May 5, 2015  
BCE File: 15120

Re: Response to Review Comments  
13 Hodgins Street, Portland, Maine  
Project ID#: 2015-00630

C-100

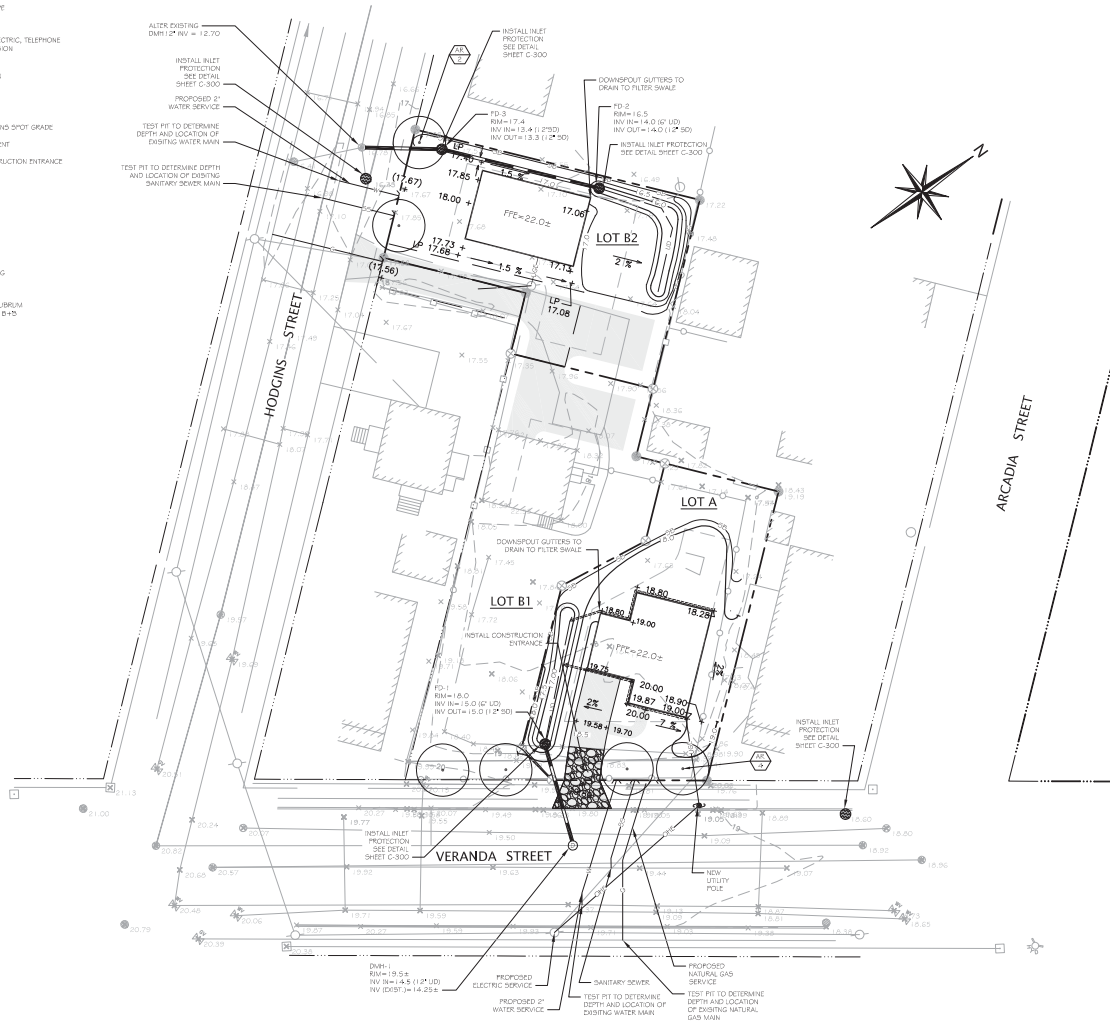
- *Please submit a revised site plan that includes the following information:*
  - *The footprint shown on Sheet C-100 labeled – C2-Erosion Control and Drainage does not match the footprint on the building plans. The two have to match exactly.*

C-100

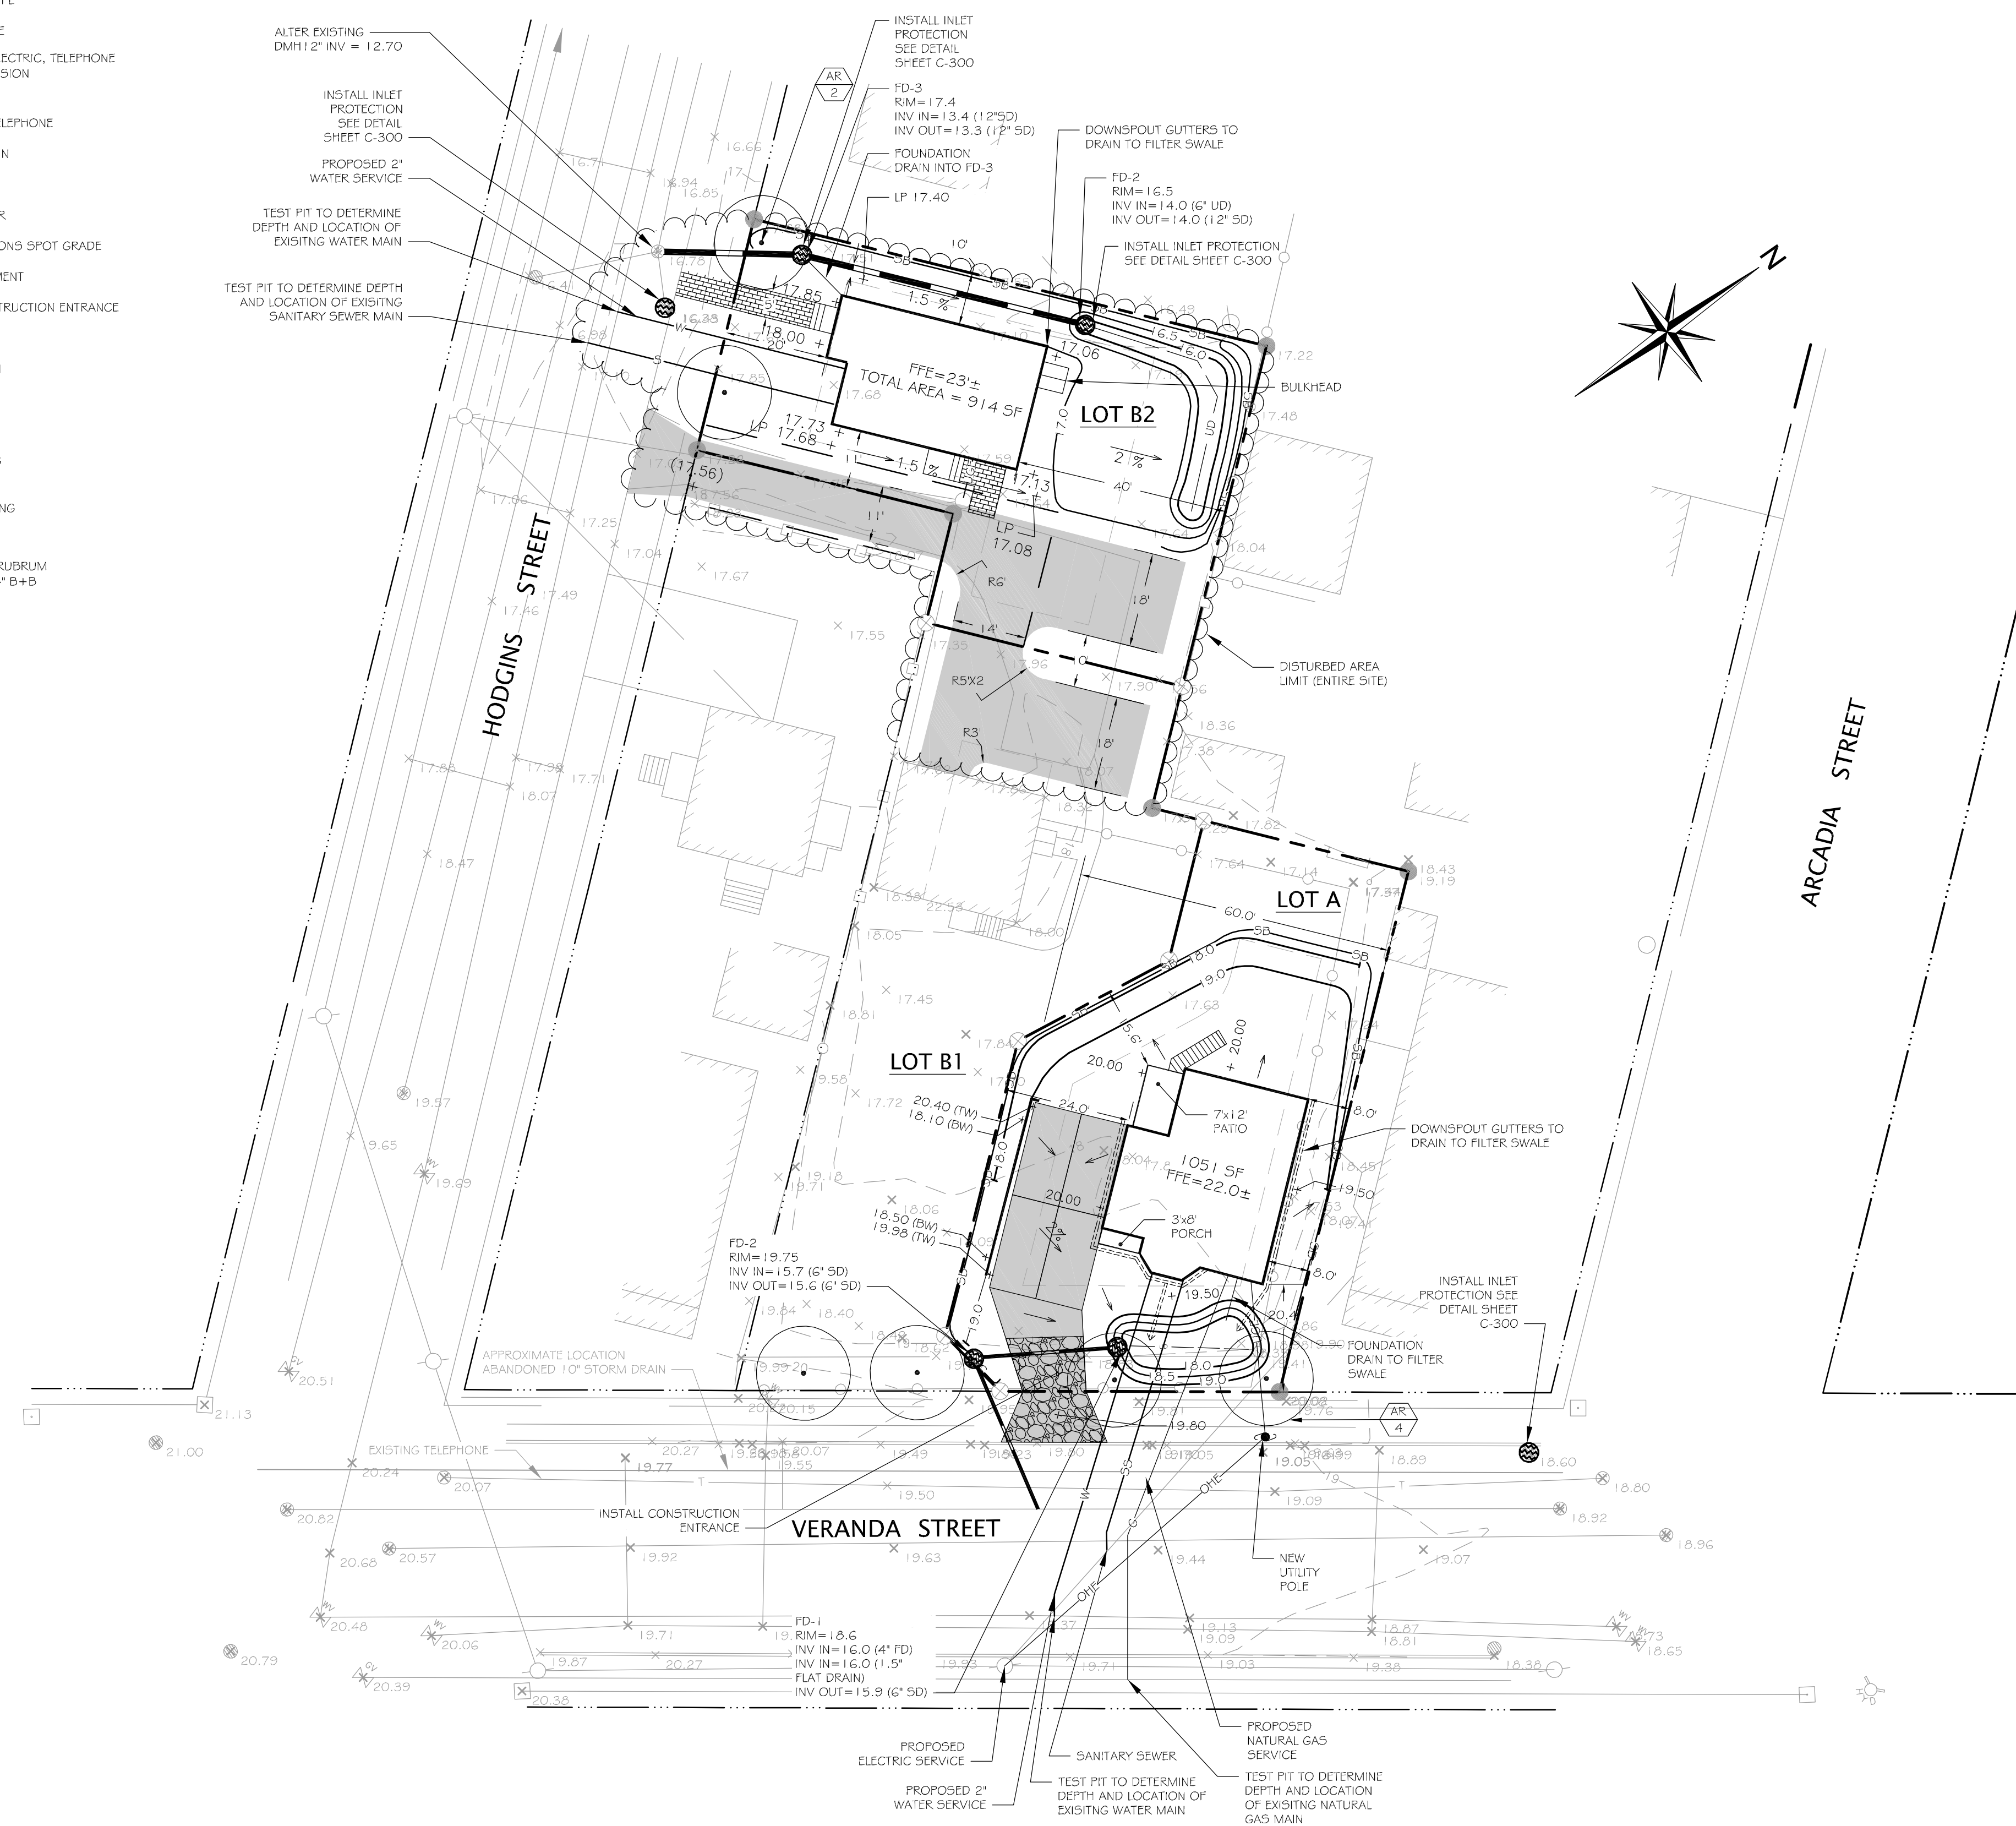
- *Please submit a revised site plan that includes the following information:*
  - *Please show the existing and proposed structures, as applicable, and the distances from all property lines. The footprint of the proposed structure does not match the footprint shown on your site plan, please revise.*

- *Please add the ground floor areas and the finished floor elevation to the site plan.*

- *Please add the locations of all proposed utilities from the street to the structure, to the site plan.*

- *Please add the soil type to the site plan.*

- *Please add to the site plan, the location, area, and limits of the proposed site disturbance.*

- *Please show on the site plan where the foundation drain will outlet.*

- *The bulkhead and any steps to grade needs to be shown on the site plan.*

Response: The existing and proposed structures are shown and are consistent between all sheets. Dimensions were added to Sheet C-100 indicating the distance between the building and property line.

Response: Floor area and finished floor elevation were added to Sheets C-100 and D-100.

Response: Proposed utility connections were extended to the proposed building.

Response: The soil type was added to the General Notes on Sheet C-100.

Response: The entire site will be disturbed in addition to a small portion of Hodgins Street. This area is shown on Sheet C-100 and is approximately 8,300 square feet.

Response: A foundation drain connection was added from the corner of the proposed building to FD-3.

Response: All plans now show the same proposed footprint.

Response: The bulkhead and steps at the front and side entrances were added to Sheets C-100 and D-100.
